# Vehicle Crossover/location plan

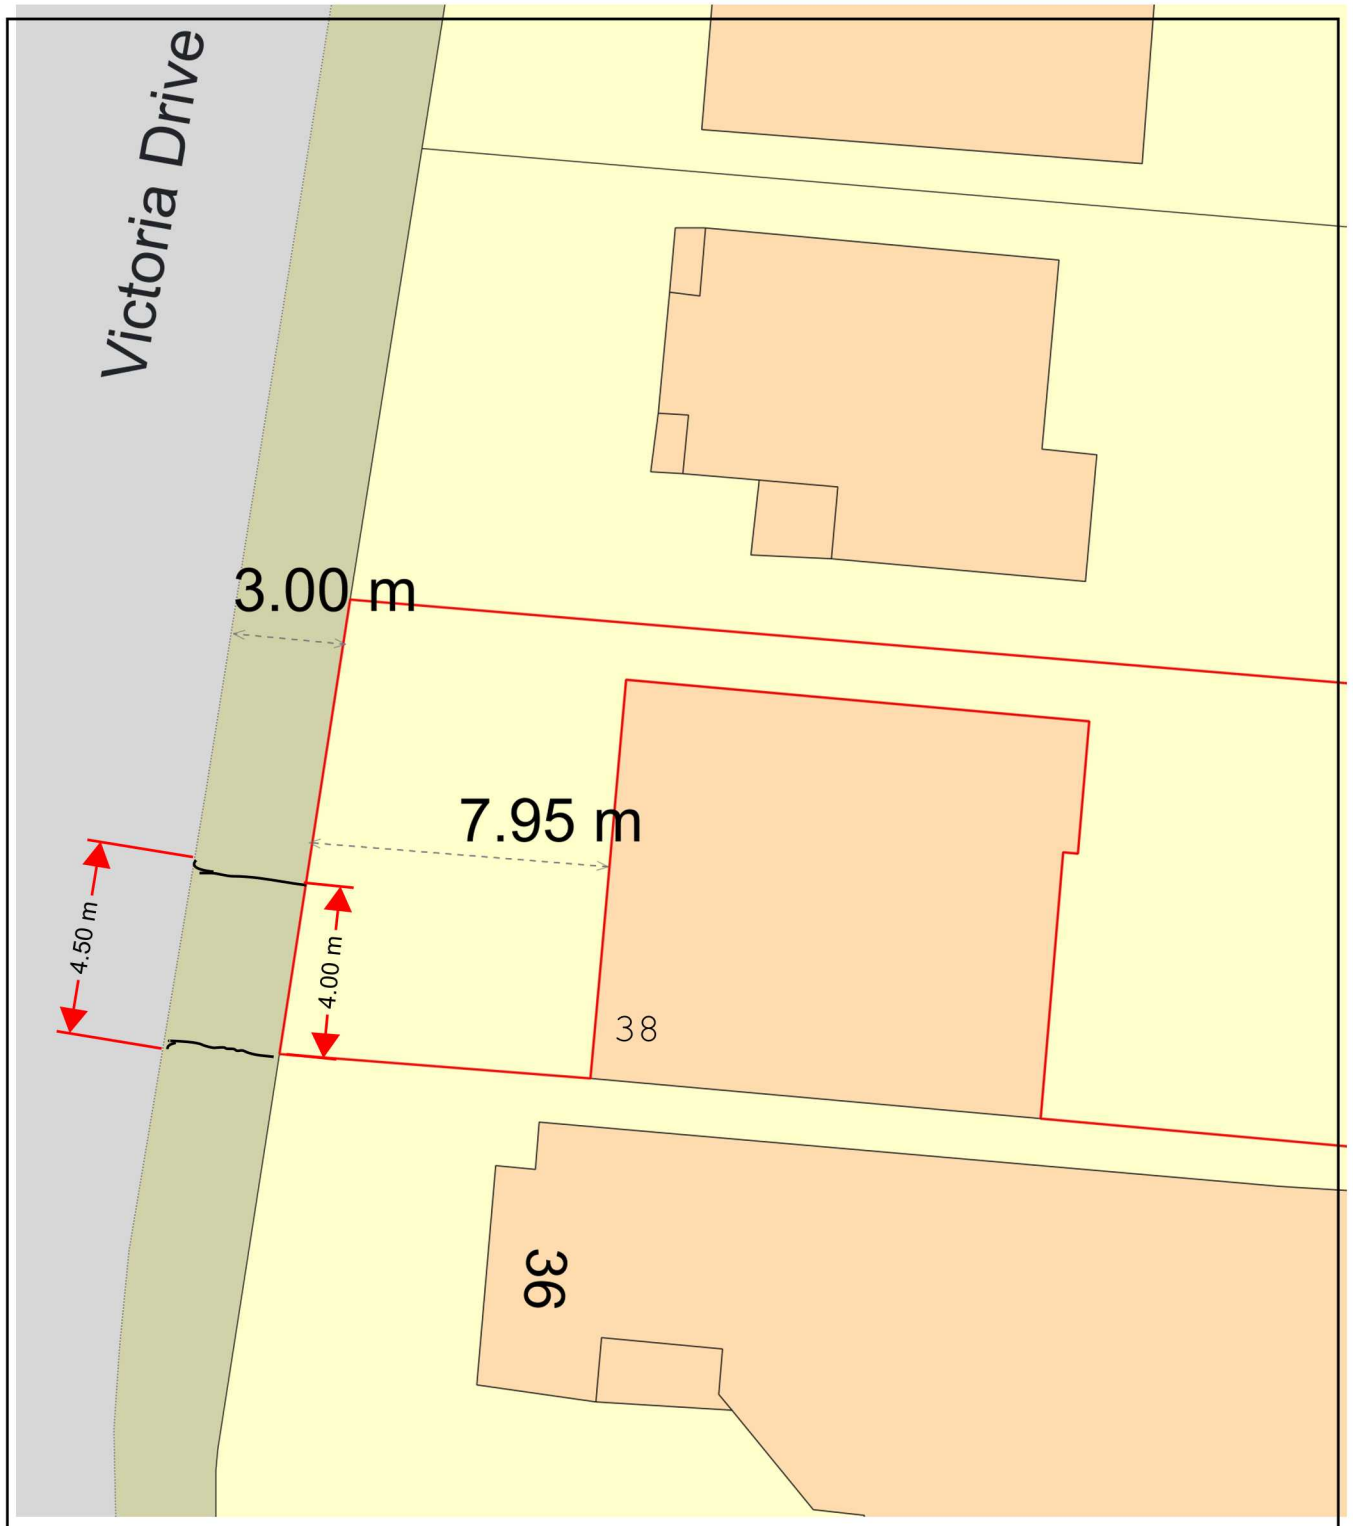
Crossover plan: The measurements listed do not measure to scale. Please review and amend accordingly.
